KITITAS COUNTY

MEMORANDUM

TO: Community Development Services
FROM: Public Works Planning Review Team
DATE: March 30, 2021
SUBJECT: LPF-21-00003 Palomino Fields Div. 6

PALOMINO FIELDS PLAT - DIVISION VI
 A REPLAT OF TRACTS 'E', AND 'H', PALOMINO FIELDS PLAT - DIVISION IV
 A PORTION OF THE S 1/2 OF THE NW 1/4 OF SECTION 27, TOWNSHIP 18 NORTH, RANGE 18 EAST, W.M.
 KITTITAS COUNTY, WASHINGTON

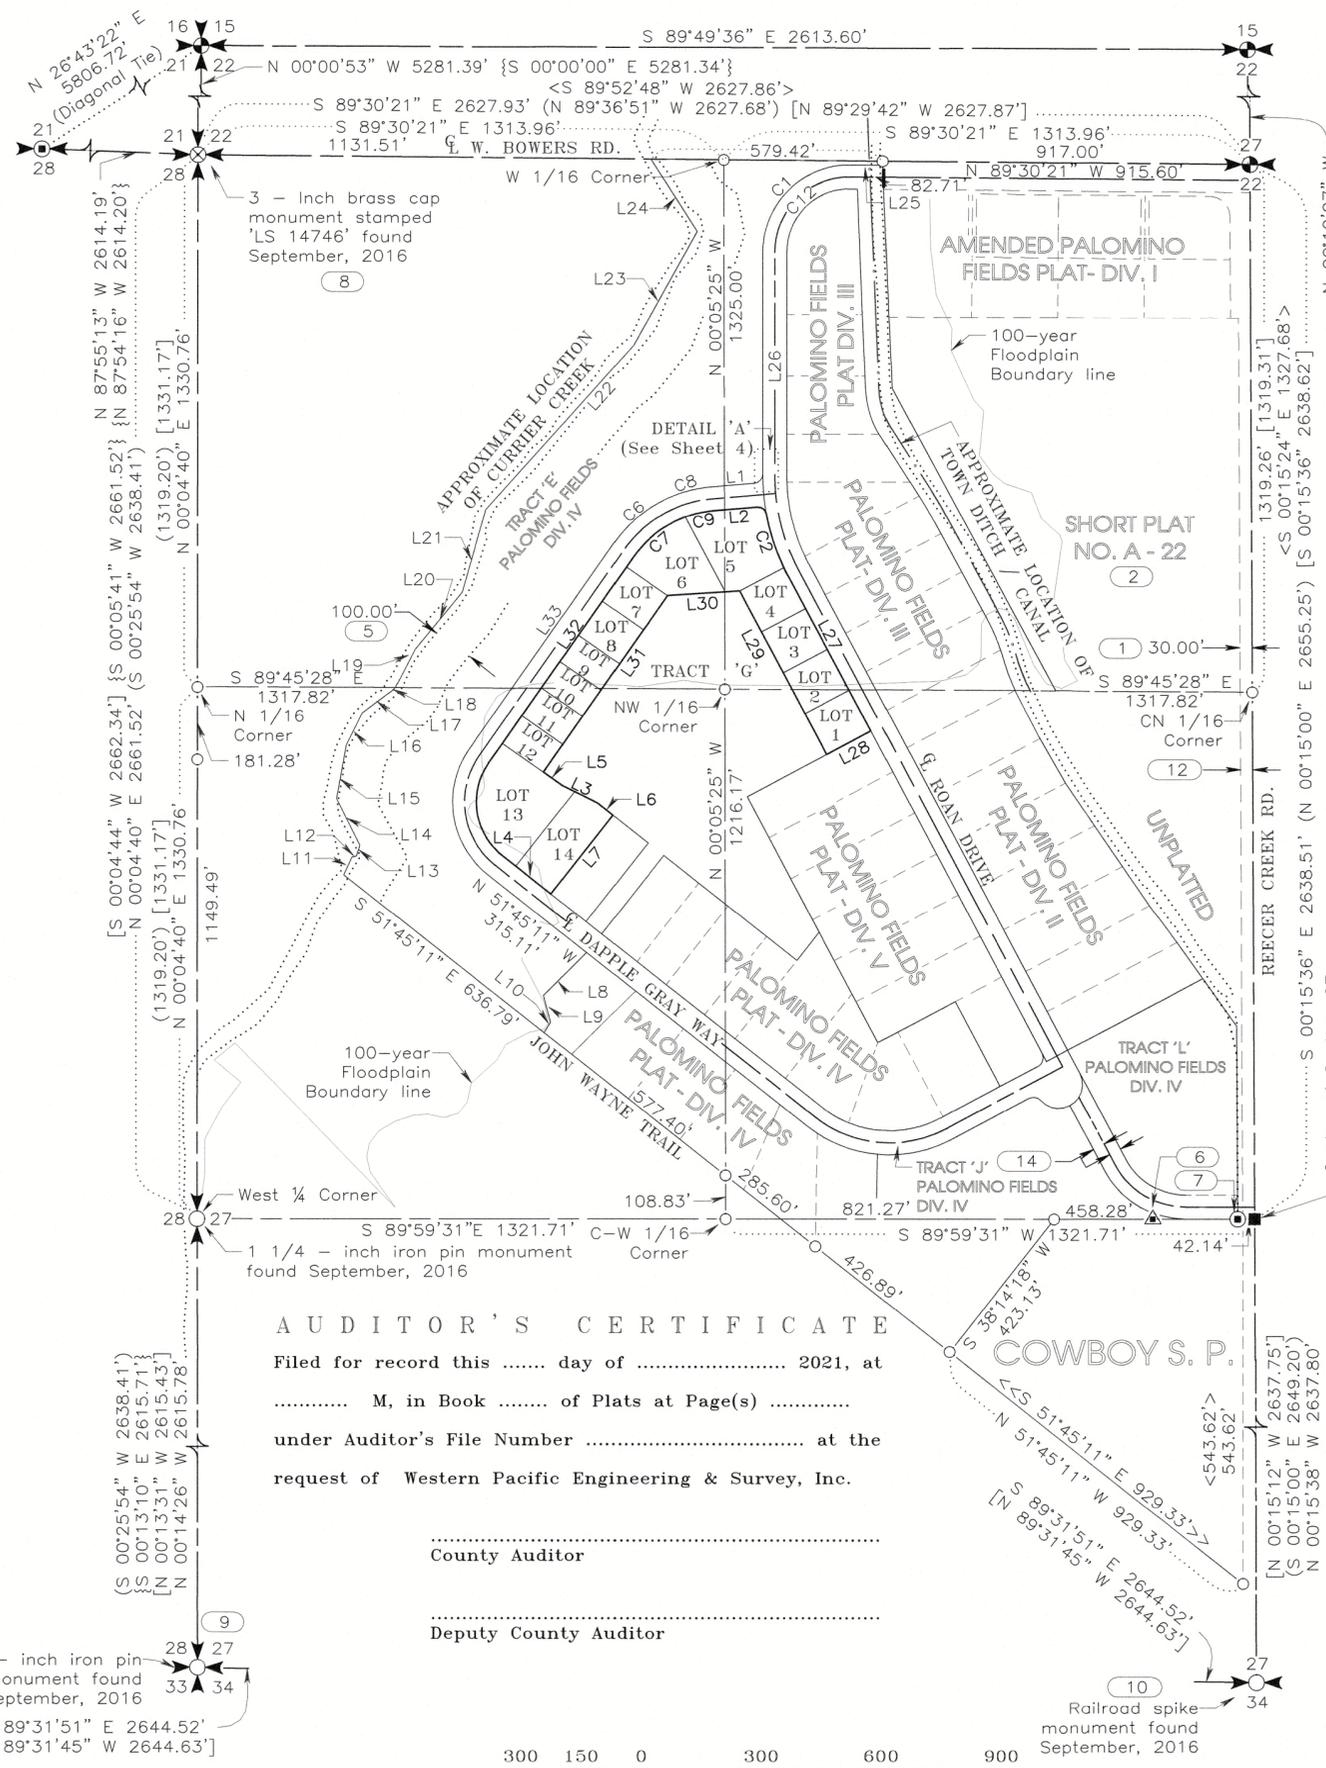
1. The title block states "A replat of Tracts 'E' and 'H'..... while the original property description only shows Tract H.

IF TRACT E IS TO BE INCLUDED AS PART OF THE PLAT

- a. include the tract label and area.
- b. provided a closure report for tract E
- c. include Tract E in the original property description

IF TRACT E IS THE BE EXCLUDED FROM THE PLAT

- a. Remove Tract E from the title block at top of page

2. Change Title block at top of page from "... S1/2 of the NW1/4 of..." to "...of the NW1/4"
3. Sheet 1 – the symbol for the N1/4 corner of Section 27 shows incorrect sections.
